**WELWYN HATFIELD BOROUGH COUNCIL
DIRECTORATE OF STRATEGY AND DEVELOPMENT**

DELEGATED APPLICATION

Application No: 6/2016/0318/MAJ
Location: Media House, Sopers Road, Cuffley, Potters Bar, EN6 4RY
Proposal: Erection of additional floor to provide 1719 sq metres of B1a (Office) floorspace in association with the use of the premises for B1 offices together with elevational alterations to the remainder of the building
Officer: Ms F Nwanze

Title; Proposed development Titchfield Group Ltd Media House, Sopers Road Cuffley, Herts, EN6 4RY Proposed site plan

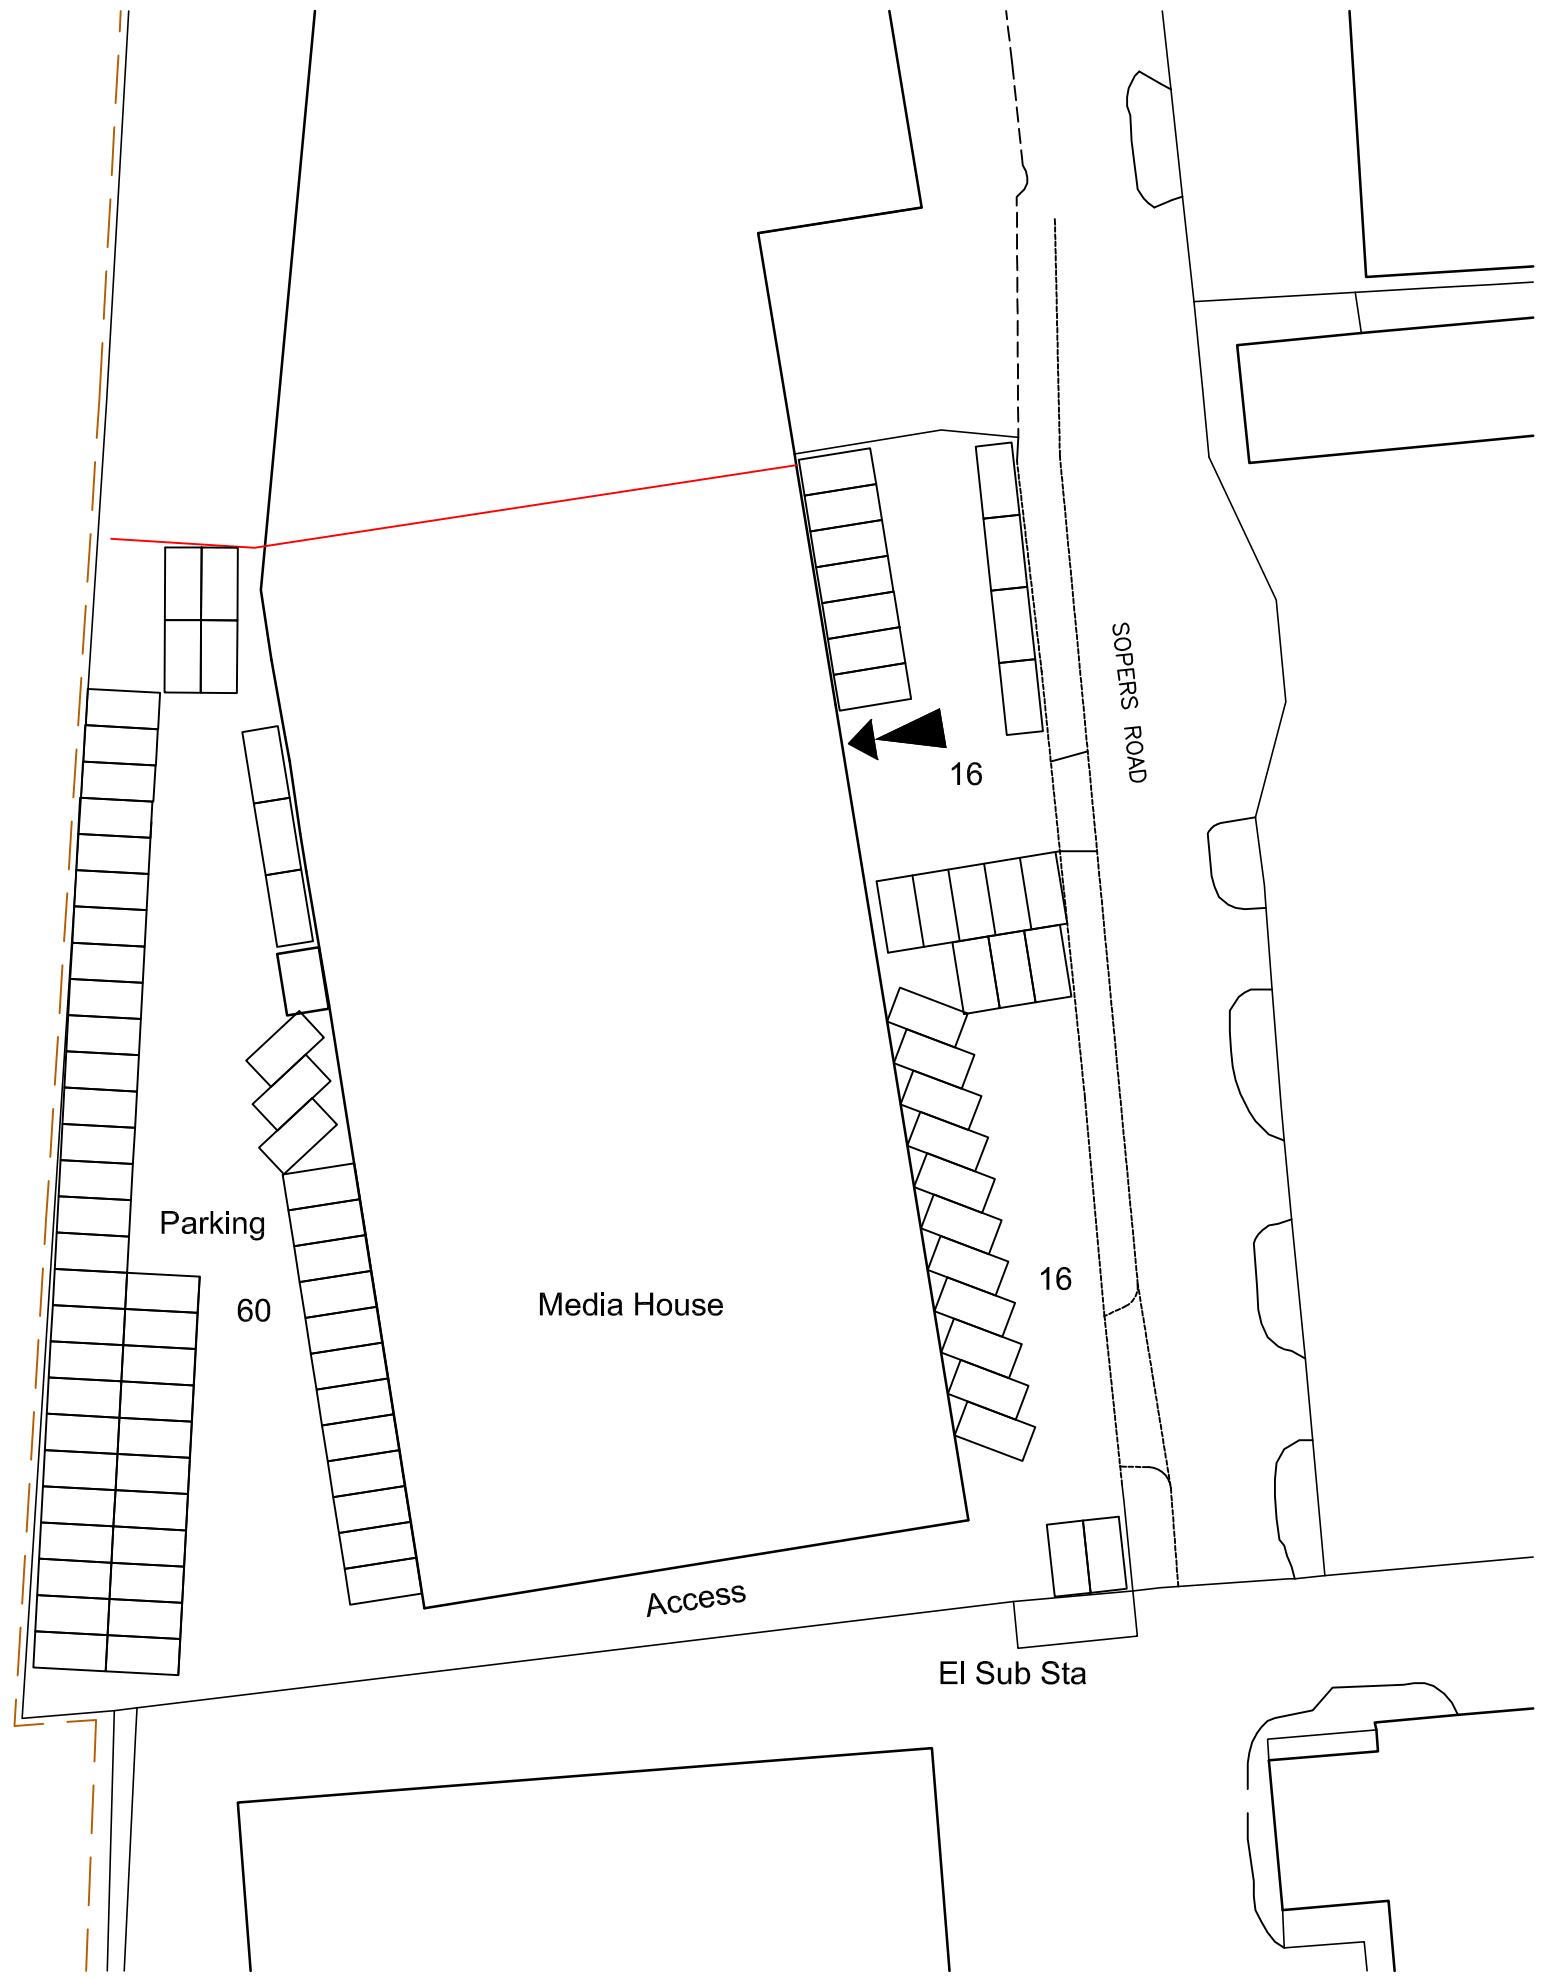
The application describes that parking for 92 vehicles shall be provided, and shall be for the LPA to determine whether provides sufficient parking is provided to serve the requirements of the increased employment space, however the Highway Authority note that in close proximity to the site is public car parking in the control of the Parish Council and parking controls exist locally (part) to control / deter parking in inappropriate locations. Any shortfall in parking is unlikely to have a significant highway impact.

I would observe that some parking is in tandem, but it is not unreasonable in a work environment for such an arrangement to be workable. Spaces parallel to direction of travel are shown at 2.4m x 4.8m and commonly a distance of 6m is recommended for such bays to ensure they're accessibility even when adjacent bays are occupied, but it is again not unreasonable to expect within an employment situation to consider this workable. Parking in such a situation can, at times, provide an informal arrangement, but I would recommend that all parking areas provided are identified with marked bays in order that the level of parking described shall be achieved representing effective use of site area. I present no objection that parking arrangement precludes through movement within the site, removing an access / egress arrangement and instead providing flows at both points of access, noting that footway activity is likely to be low.

No new or amended access is provided as part of the development, and existing access points (two off) are constructed to serve the industrial nature of the site providing wide vehicle crossovers a both points. As the development proposals include loss of B1(c) use (Light industrial) and the use becomes solely B1(a) offices, these accesses as presently provided are in excess of operational requirements. The Highway Authority would recommend that concurrent with any grant of consent, and prior to occupation, the access points be reduced in width to reflect the change in vehicle type attending the site. Such a requirement shall improve footway conditions at this point (as well as potentially provide additional on-street parking capacity) Cycle parking is described as remaining at 10 spaces, it is unclear on submitted plans

2. No development shall take place until a revised plan has been submitted to and approved by the Local Planning Authority in writing showing the following

* Cycle parking provision

* A minimum of 10% disabled parking provision.
